Reference Planning Application m/80/19/PL

The new developers of the now-derelict Poultry Farm site off Yapton Road in Middleton-on-Sea, Frontier Estates, seem to grossly underestimate the amount of traffic the Care Home will generate and the amount of on-site parking required.

SITE LAYOUT

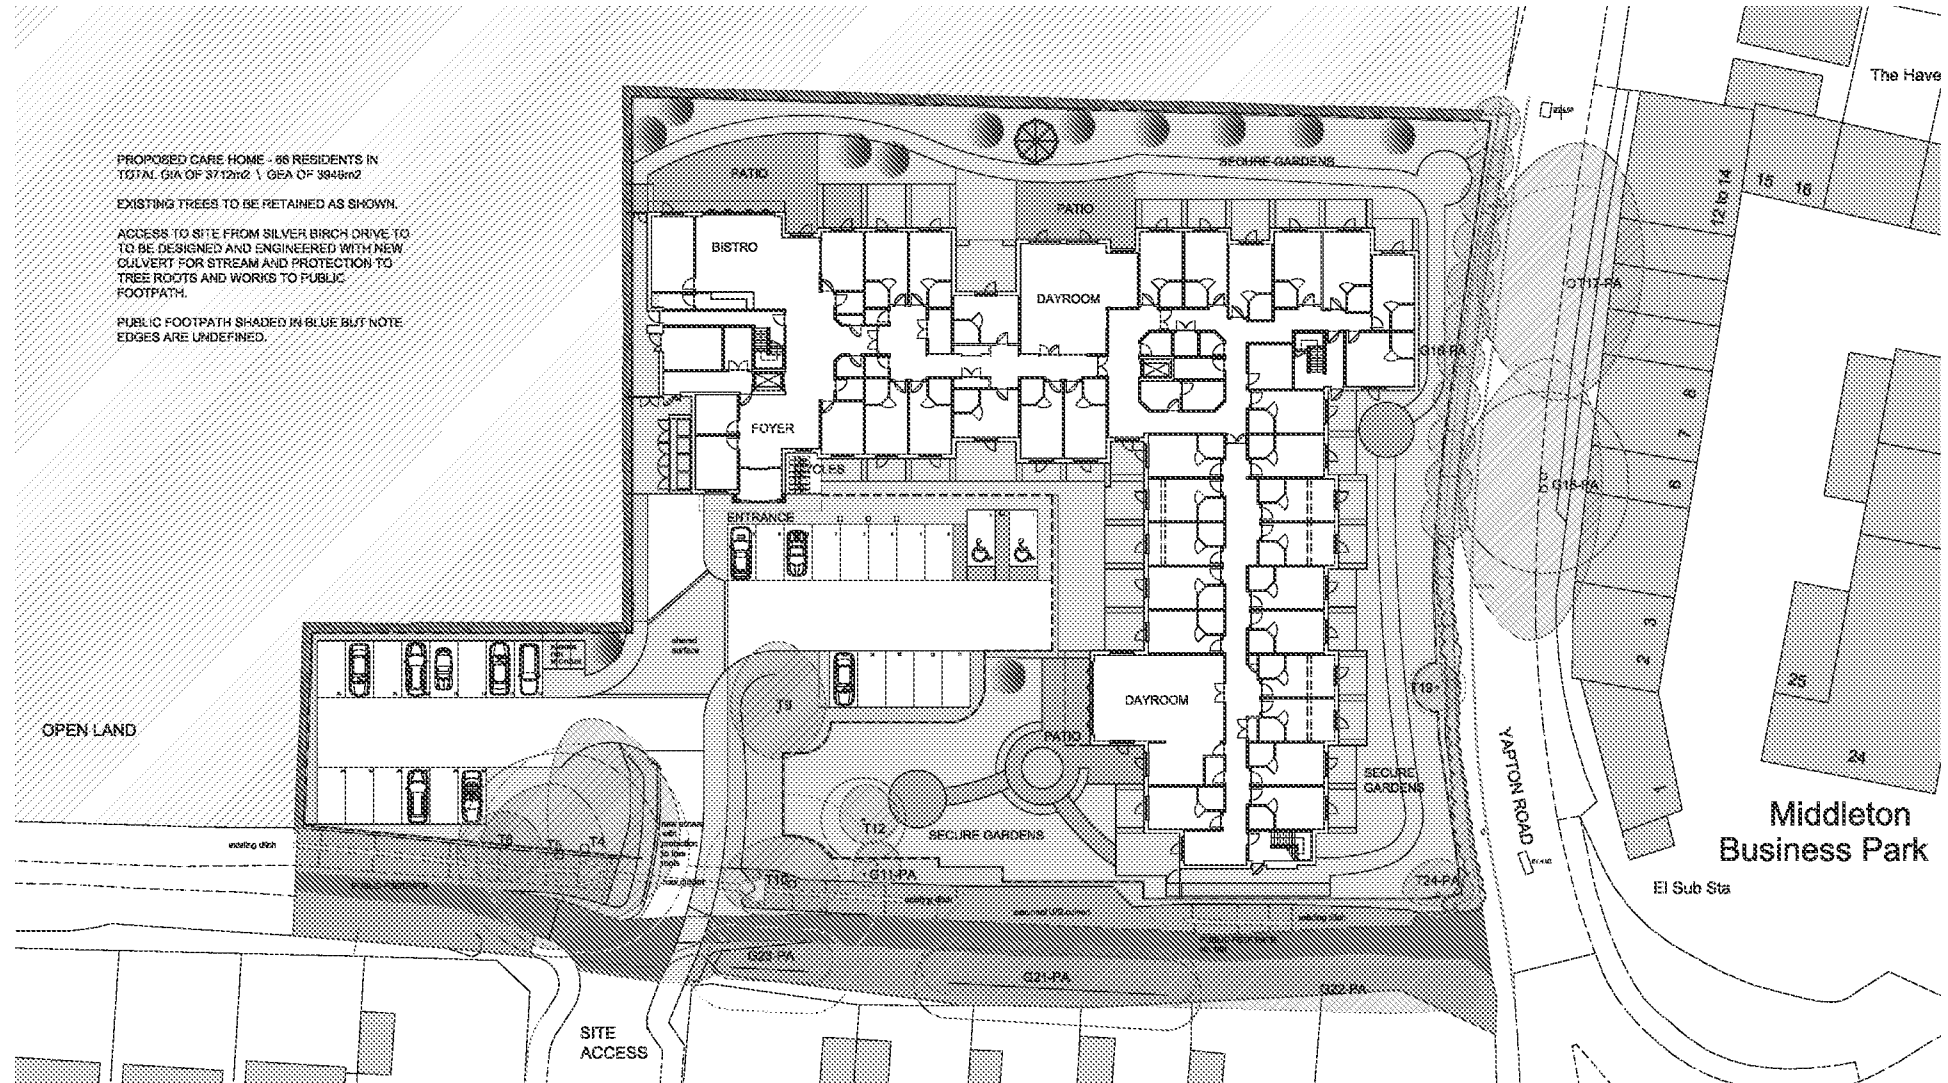
Only 26 car parking spaces at this site is unrealistic. If there are 20 - 25 staff on site at any one time, with three 8-hour shifts, at changeover the number doubles for a period. The brochure anticipates that only half the staff will use their own cars. Perhaps a few will share cars, others come by bus. The nearest bus (Route 600) runs through Middleton village, starting at 6.57 am Monday to Friday, and 7.16 am on Saturday. The last bus runs from Middleton-on-Sea at 9.10 pm. So late evening weekday staff changes cannot travel by bus. There is no Sunday service. The walk from the Care Home takes 10 minutes and the road is unlit.

With this volume of traffic connected with the Care Home the access from Silver Birch Drive is clearly inadequate. The existing tarmac cul-de-sac has two parking lay-bys and when these are in use is just wide enough for two cars to pass (5.9 metres). Commercial vehicles could not pass.

The developers' plan shows single track access north of the footpath for some 20 metres (there's no scale on the brochure plan, but it is two-thirds of the width of the existing access road at its mouth from Silver Birch Drive, i.e. 3.9 metres) so ambulances and utility vehicles will need traffic lights or enormous cooperation and courtesy.
